PLANNING DECISION NOTICE – REFUSAL

S6/2003/136/FP

ERECTION OF A FIRST FLOOR SIDE EXTENSION

at: 131 THE RIDGEWAY, NORTHAW, POTTERS BAR

first floor plan

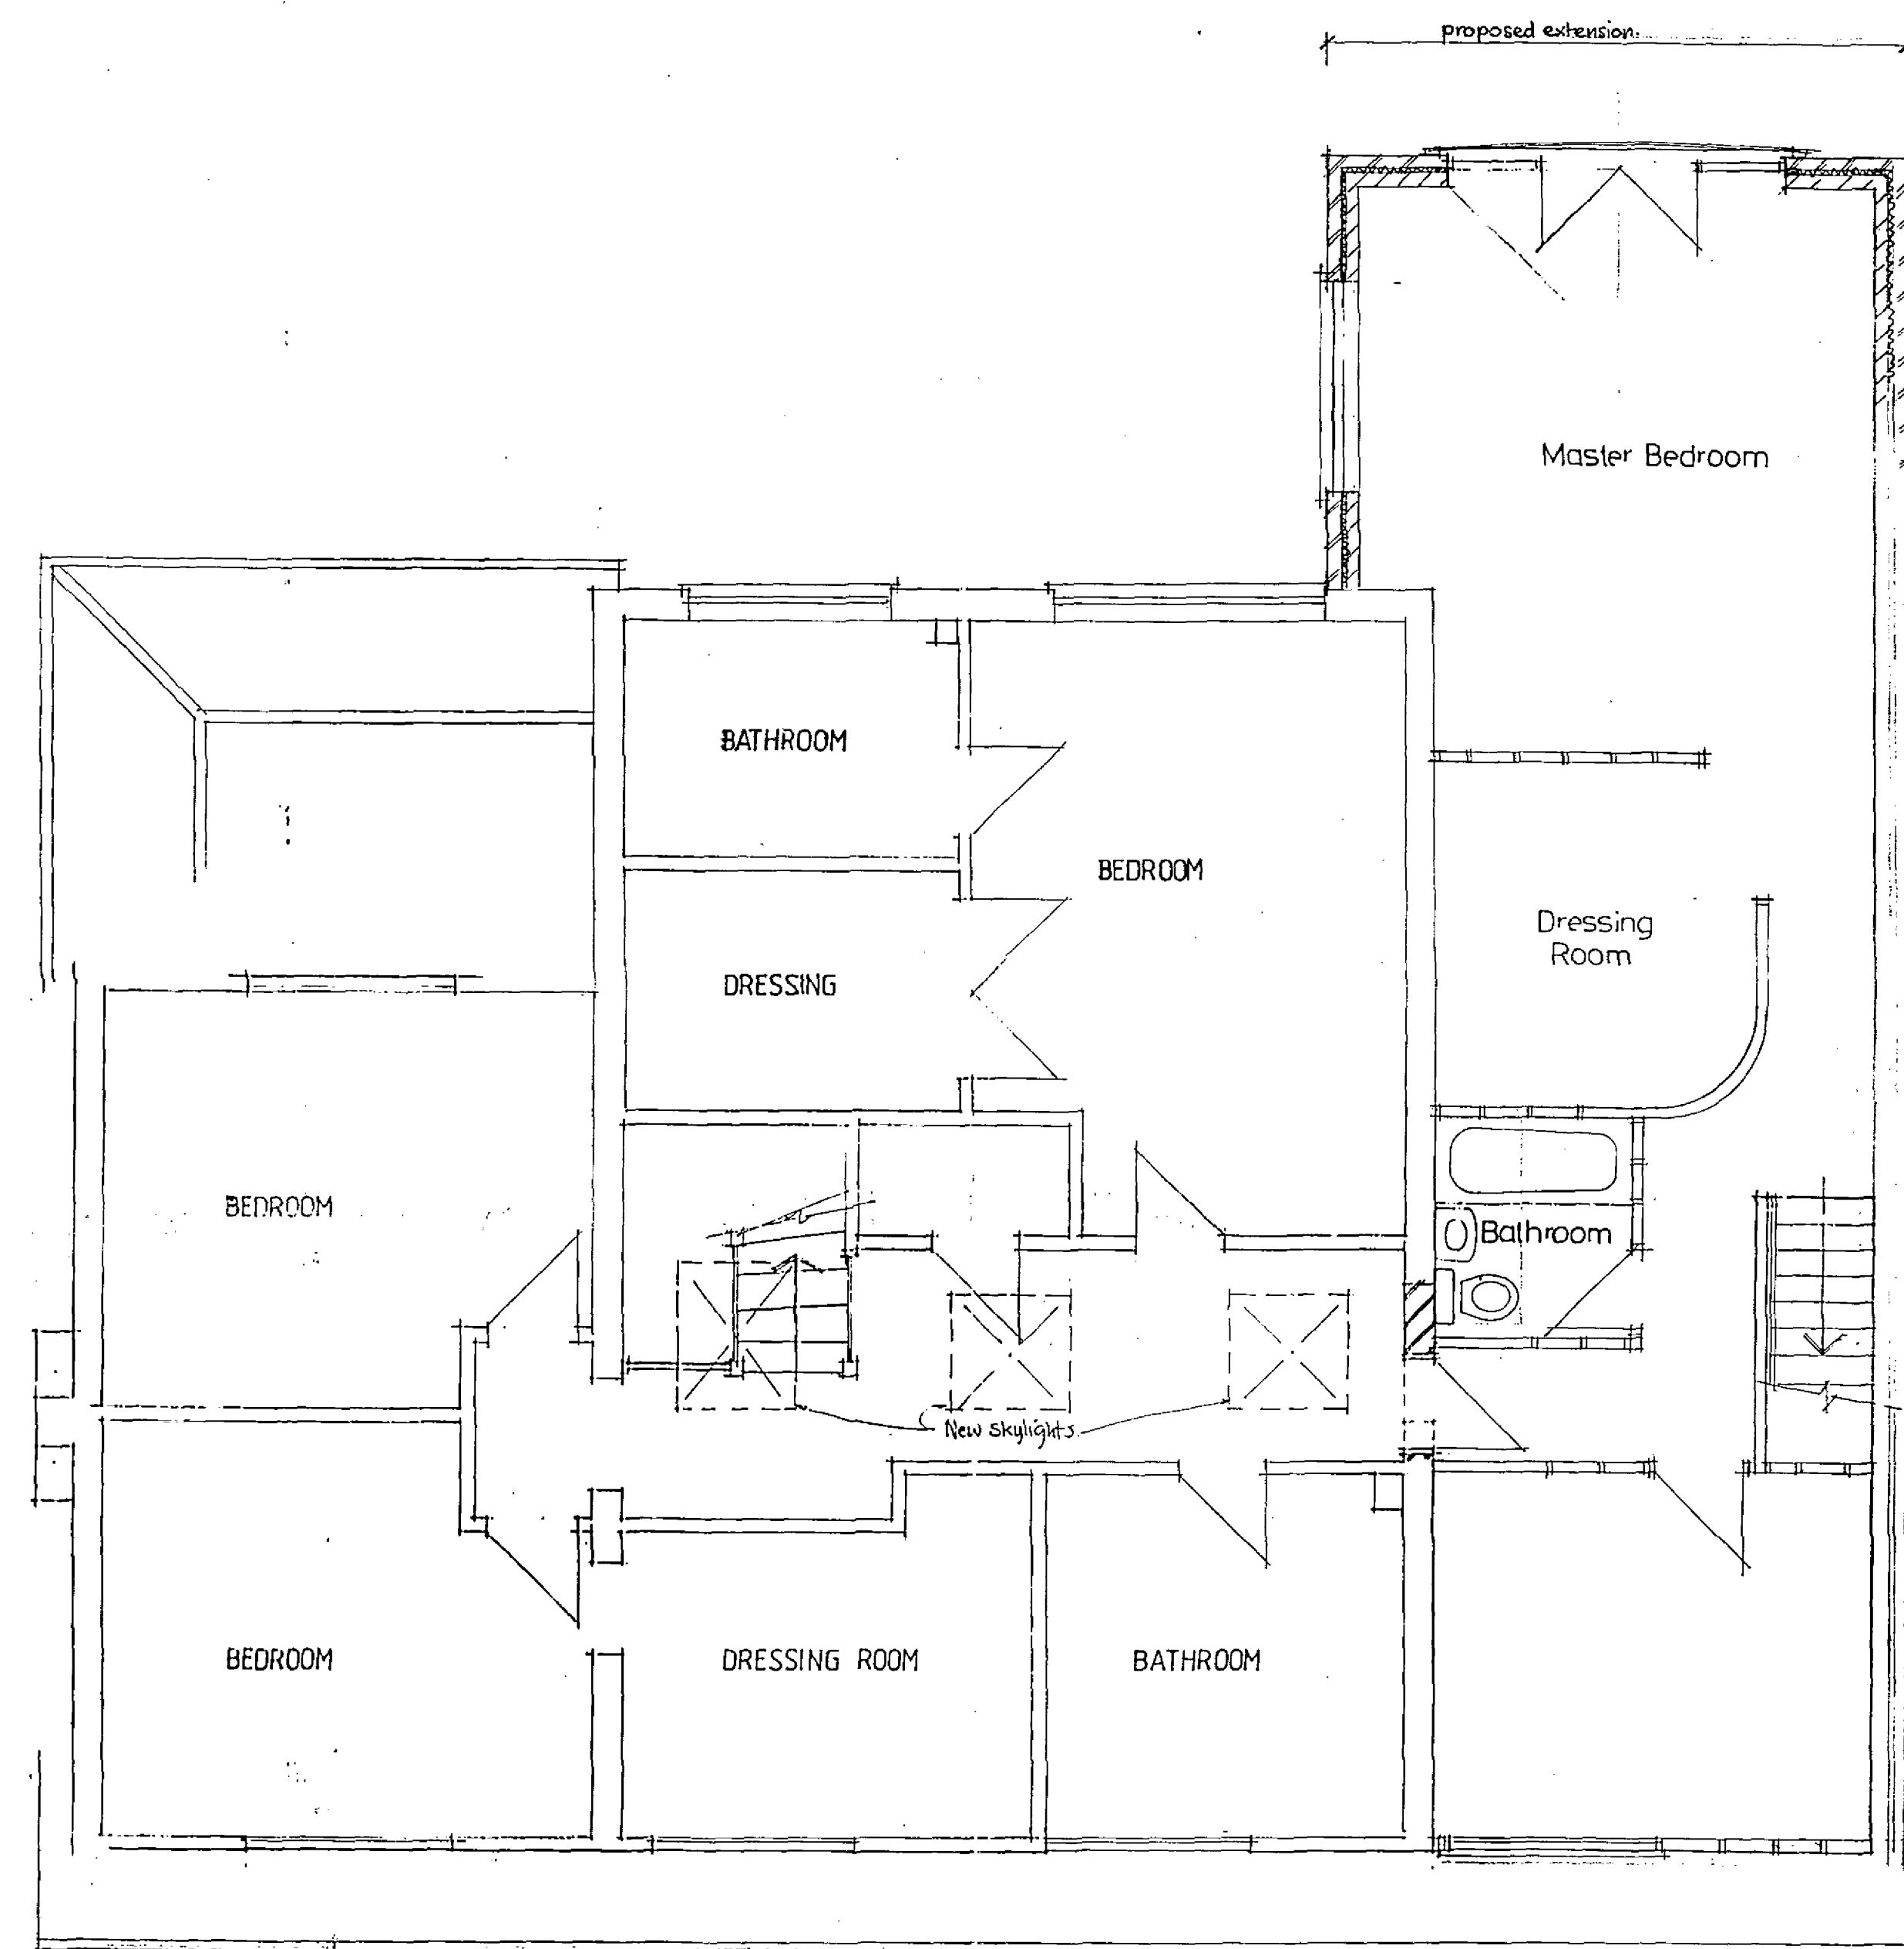
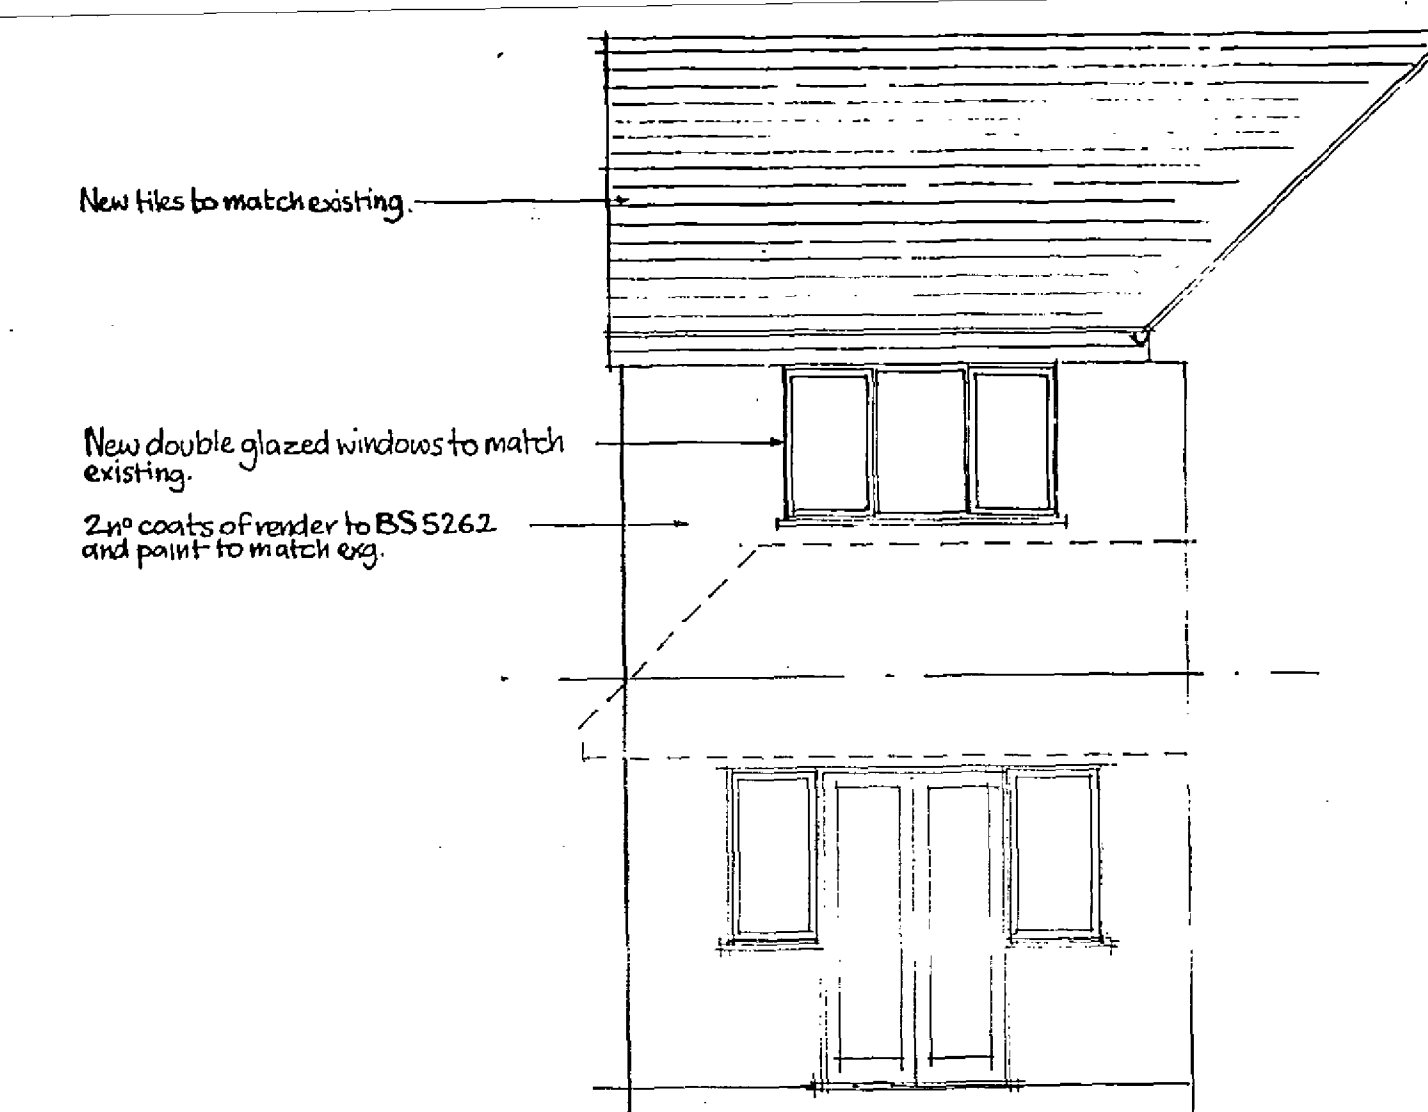
1. The application site is located within the Metropolitan Green Belt where only certain forms of development, including limited extensions to residential dwelling houses that, in accordance with Policy 5 of the Hertfordshire County Structure Plan Review 1991 - 2011 and Policy GB5 of the Welwyn Hatfield District Plan Alterations No 1, 1998, do not have an adverse or disproportionate impact upon the character, appearance and visual amenity of the surrounding countryside, may be permissible. Together with previous extensions to the dwelling, the proposal represents a cumulative increase in the floorspace of the dwelling of 201.4%. This increase in floorspace, over and above that of the original dwelling would have a disproportionate impact upon the character and appearance of the surrounding countryside and would have an adverse impact upon the openness of the Green Belt. As such, the proposed development is contrary to Policy 5 of the Hertfordshire County Structure Plan 1991 - 2011 and Policy GB5 of the Welwyn Hatfield District Plan Alterations No. 1, 1998.

2. By virtue of the proximity of the extension to the flank boundary of the curtilage with No. 133 The Ridgeway, the extension would appear unduly dominant and visually intrusive when viewed from that dwelling. The resultant dwelling would appear cramped within its plot to the detriment of the street scene. Furthermore, less than one metre would remain between the flank elevation of the extension and the side boundary of the curtilage. The proposed development is therefore contrary to Res Criteria 22 and 23 of Appendix A of the Welwyn Hatfield District Plan Alterations No. 1, 1998.
